2171/PJS//
12th March 2020

Proposed rear extension to 28 Wentworth Close, Barnham PO22 0HS
Your Ref: BN/27/20/HH.

proposed roof plan

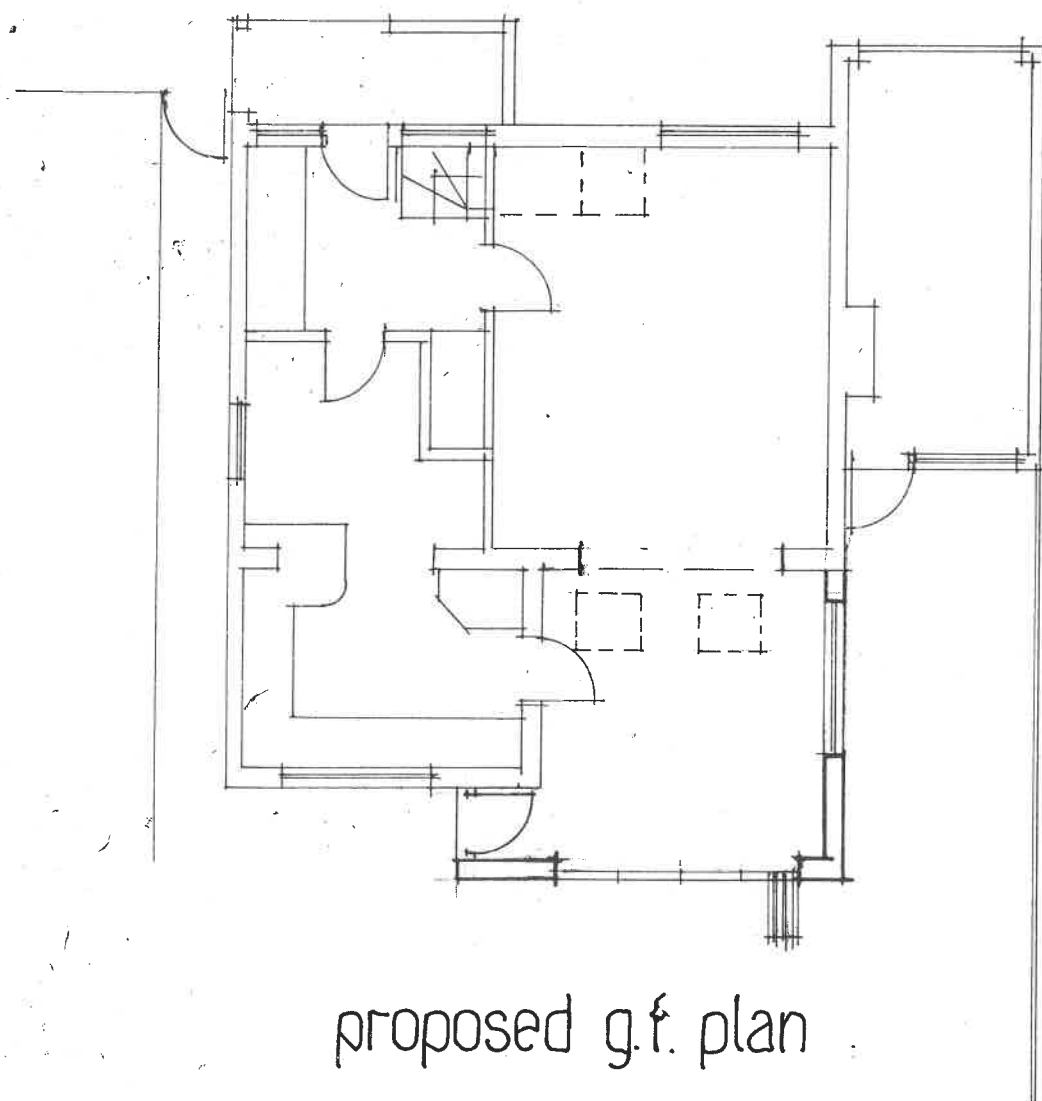
- 1 3 copies of revised drawing No. 2171.3a are enclosed showing a named road on the location plan (already shown on the site plan).
- 2 The proposed extension has been highlighted on drawing No. 2171.3a.
- 3 Dimensions to the nearest boundary and adjoining property are now shown.
- 4 A proposed roof plan has been added to revised drawing No. 2171.2a and 3 copies enclosed.
- 5 An existing roof plan has been added to revised drawing No. 2171.1a and 3 copies enclosed.
